CUMBERLAND
CITY COUNCIL

Ref: OA2021/0006

Subject: Request for comments-State Significant Development (SSD)
Application No: OA2021/0006
Property: 14 & 16 Kiara Crescent YENNORA NSW 2161
Proposal: Ministerial Consent - Yennora Liquid Waste Treatment Plant (SSD-10407)

Council has reviewed the submitted information and the Response to Submissions (RTS), and requests that the following matters be addressed:

LRGID

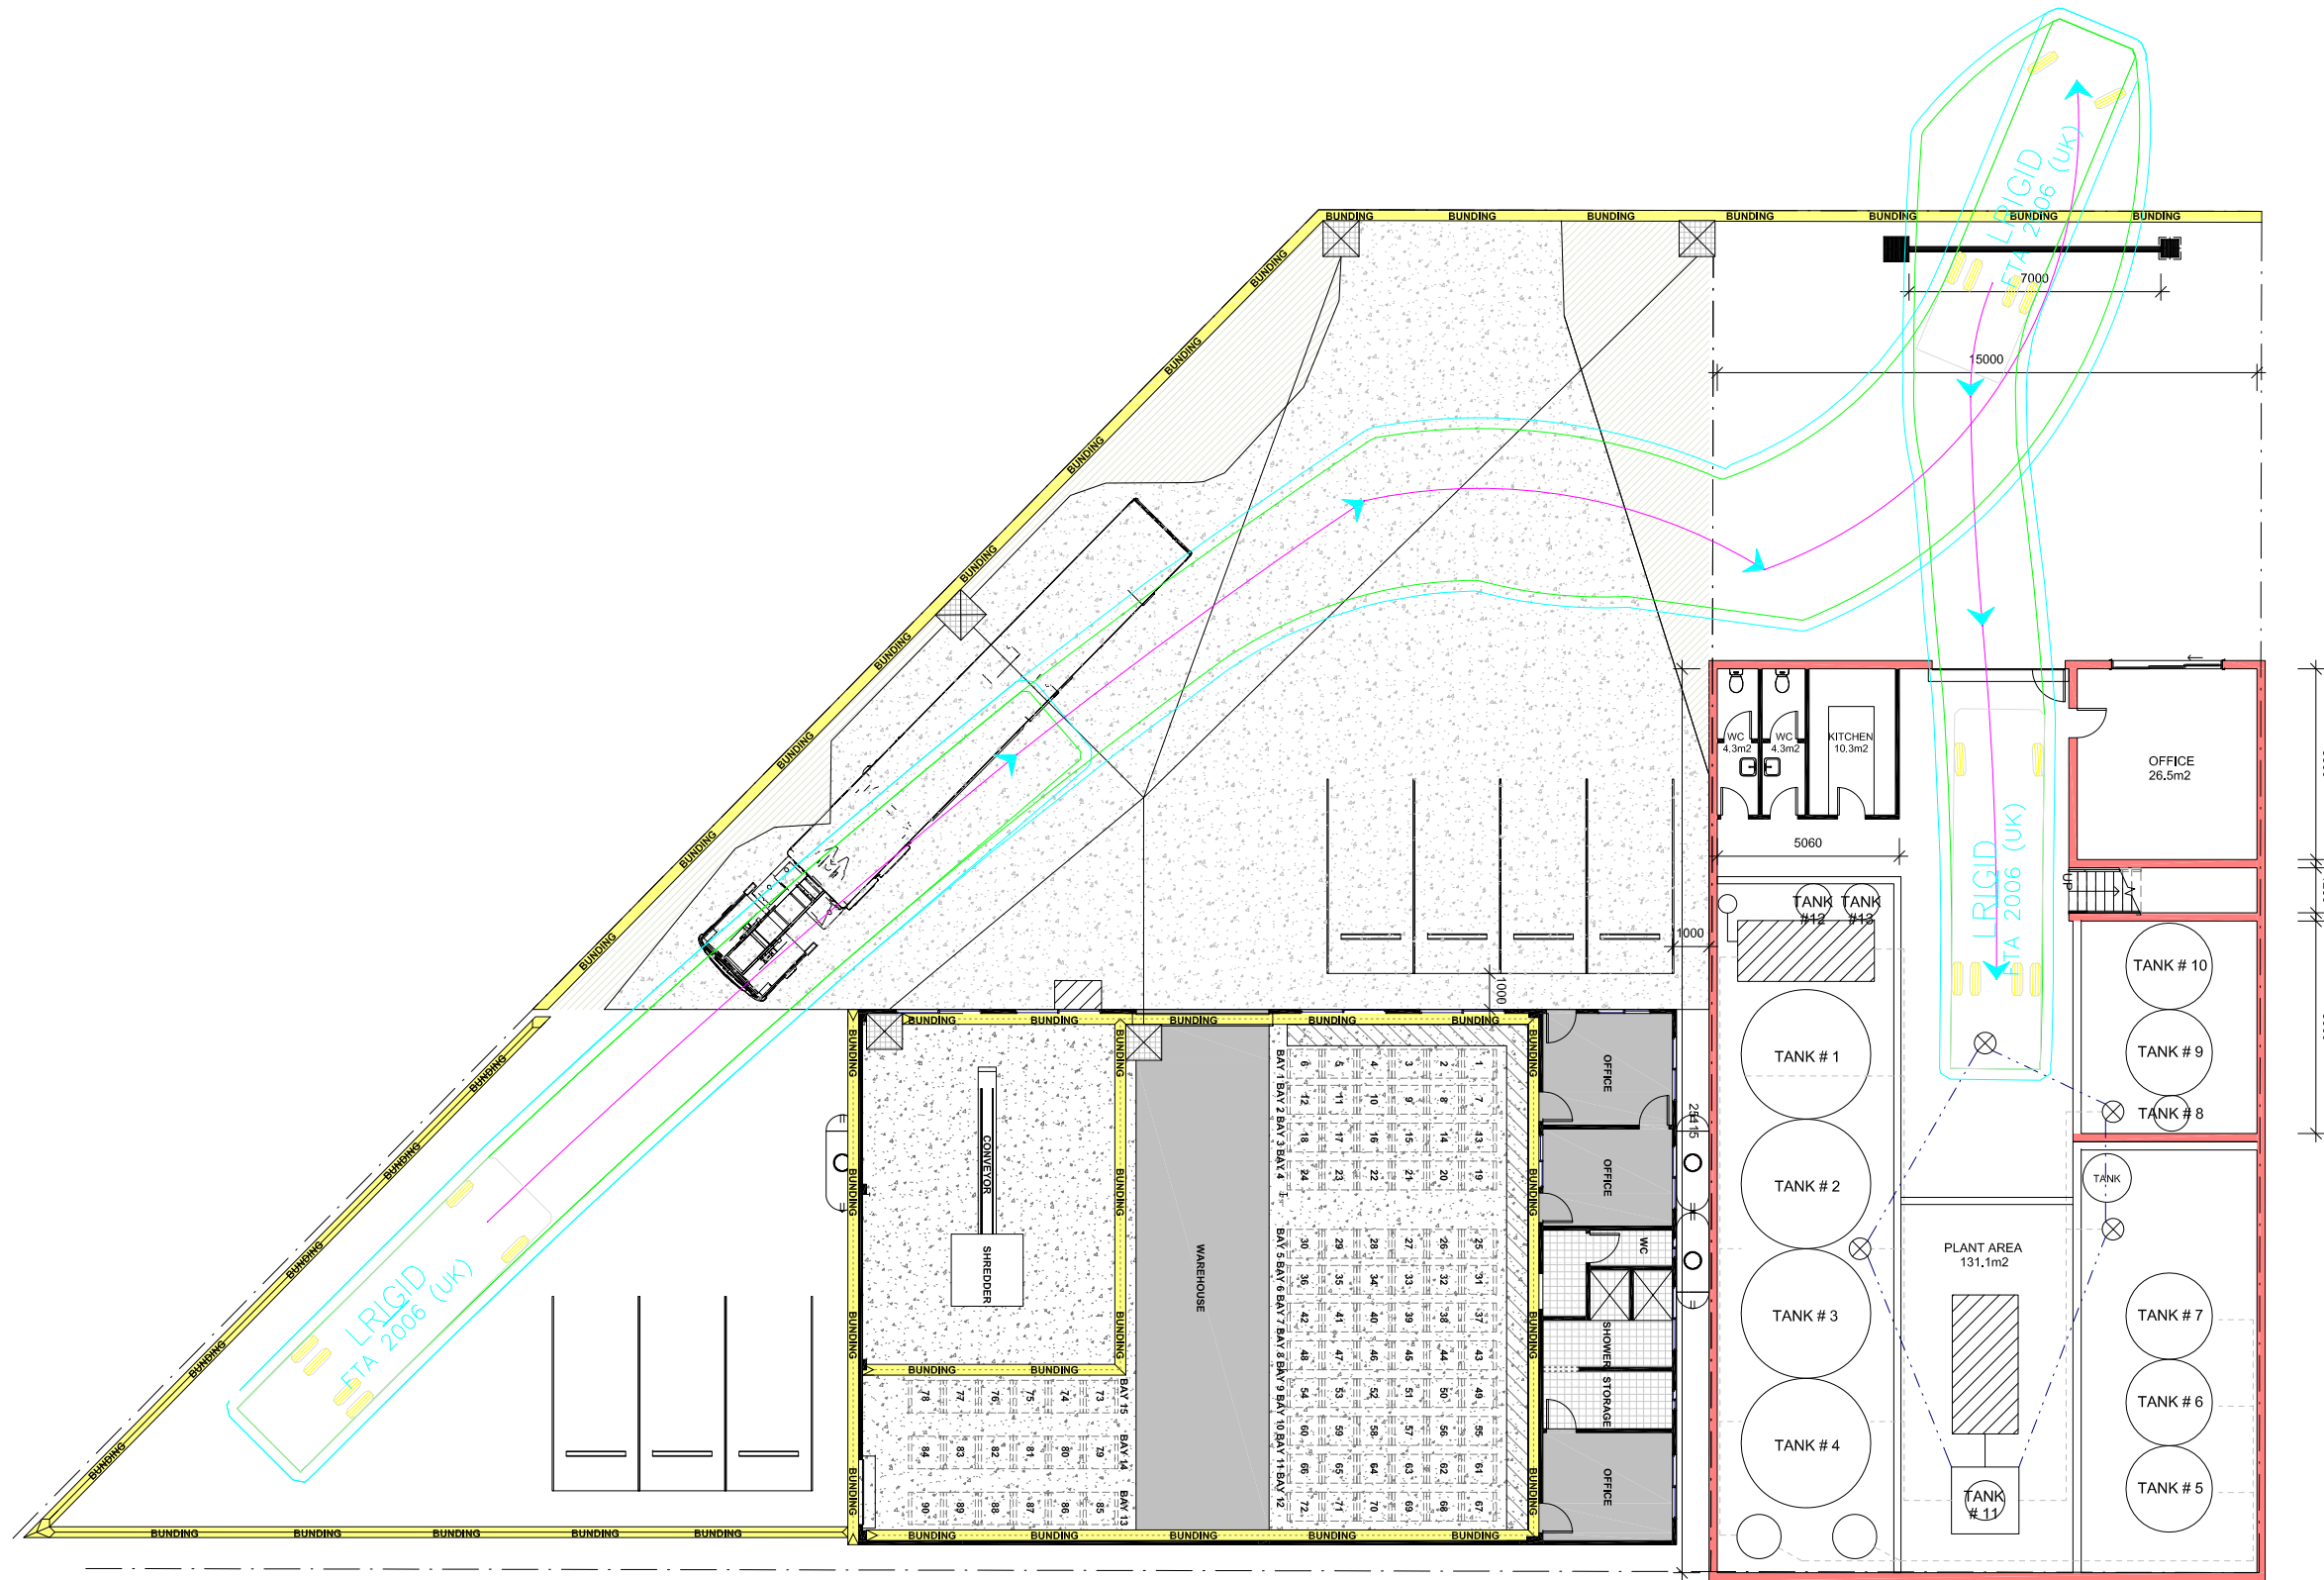
- d) Council will not support the proposed driveway widening. Driveways are provided for the site access only. All the turning manoeuvring shall be provided within the site. A separate approval shall be obtained from Council's Engineering Section for any modification to the driveway.

- e) Reverse manoeuvring in Council's land is not permitted. It will compromise the safety. Vehicles should enter and leave the site in a forward direction.

- f) Proposed 4 point turn truck manoeuvring movement is not acceptable. Manoeuvring shall be limited to three point turn. Multiple point turn (more than 3 points) will result in additional time for the turning and manoeuvring thus overlapping with the arrival of another vehicle (truck) and causing obstruction and delay. Enough space must be provided for manoeuvring and turning with the minimum delay.

- i) Parking layout shall comply with Australian standard AS2890.1 and AS2890.6.
- j) All the vehicles shall enter and leave the site in a forward direction.
